**Howerton Services, PLLC**  
**License # P-1716**  
3513 Cathedral Bell Road  
Raleigh, NC 27614  
(919) 270-3460

Subject: 6216 Ponderosa Road  
Sanford, NC 27332  
Framing Inspection Letter  
Harnett County Permit #: SFD2008-0048

Based on the request of the Contractor, I reviewed 5 items from the framing inspection notice for code compliance. My assessment and recommendations are as follows:

**CEILING FRAMING
PLAN**

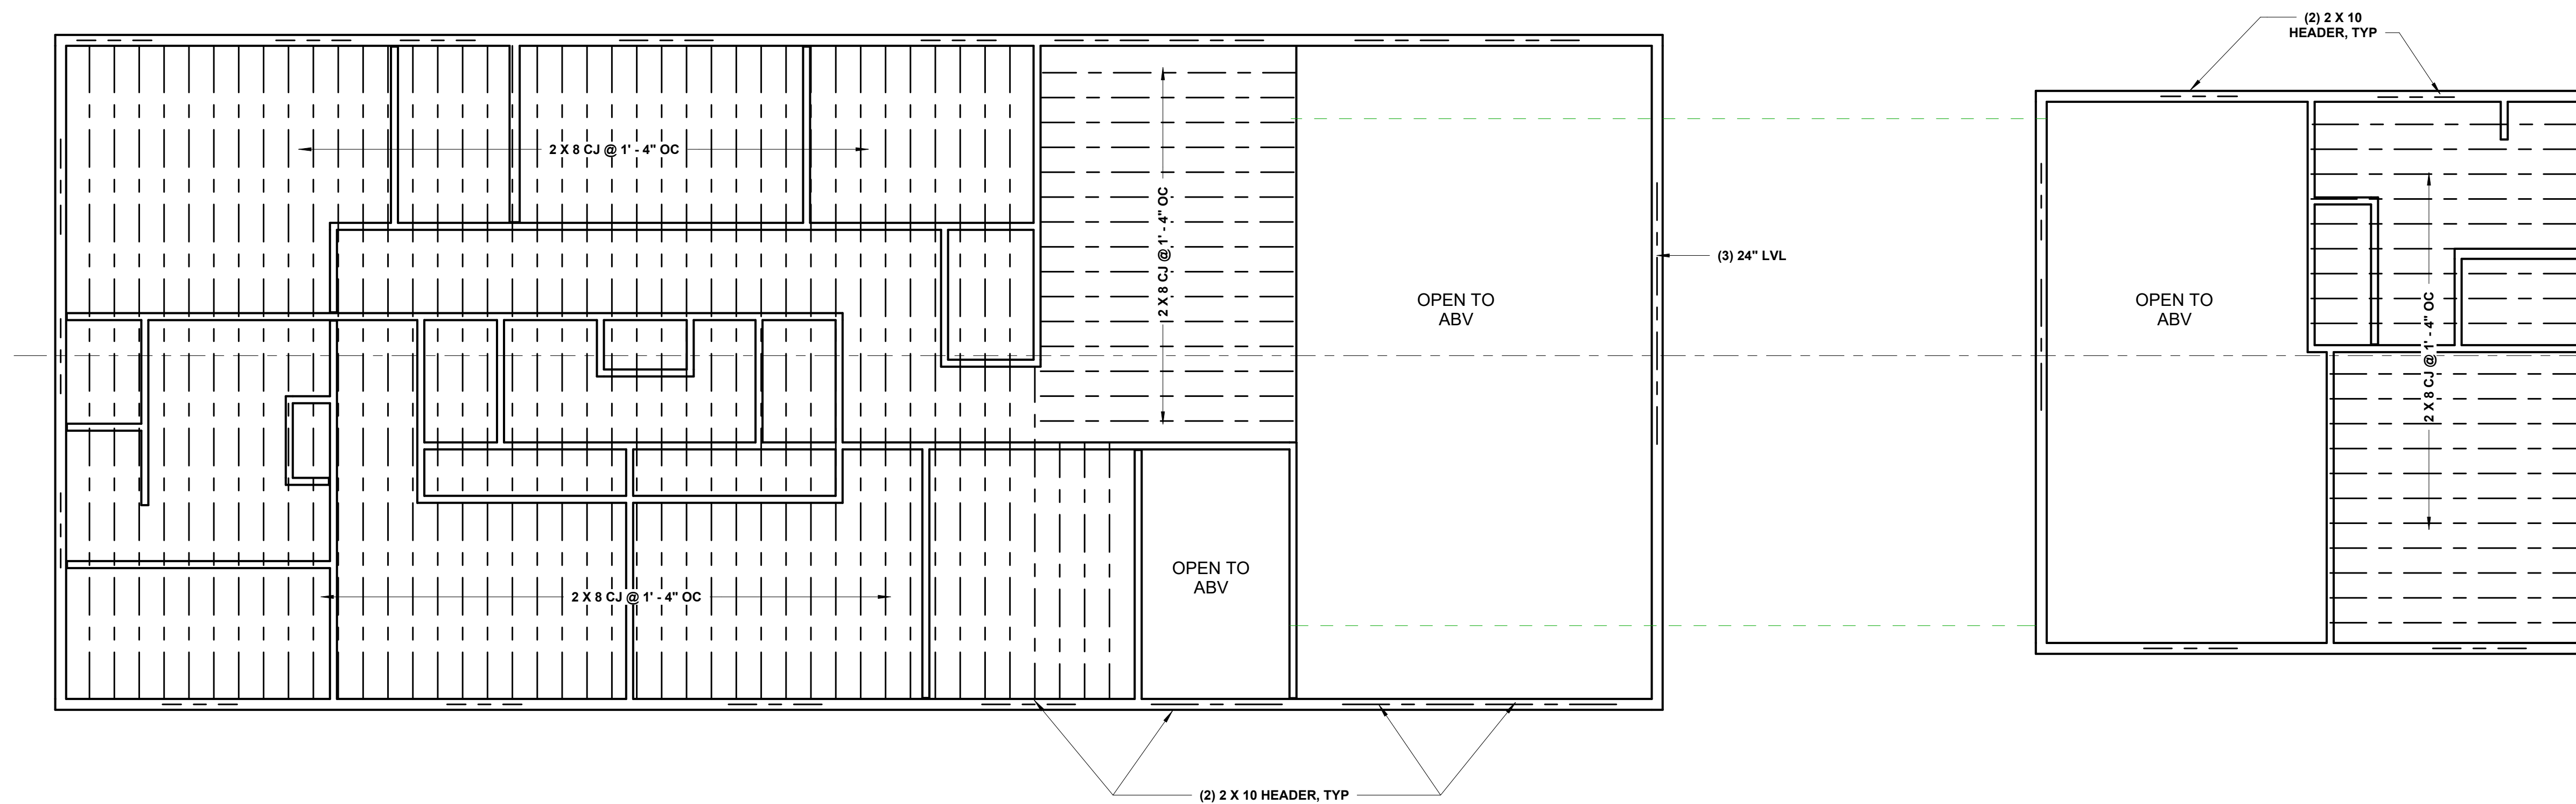
- Item 2: The ceiling joists in the small hallway are over spanned. The Contractor doubled 2 of the ceiling joists the hallway. The ceiling joists are acceptable.

- Item 4: The Contractor added a joist to the existing joist at the attic access hole. The new double joists on each side of the attic access are acceptable.

- Item 5: There is a double 1 ¾”x 16” LVL in the middle of the house supporting the ceiling joists. The Contractor added 2 rows of ¼”x 3” structural screws spaced at 12” o.c. The LVL beam is acceptable.
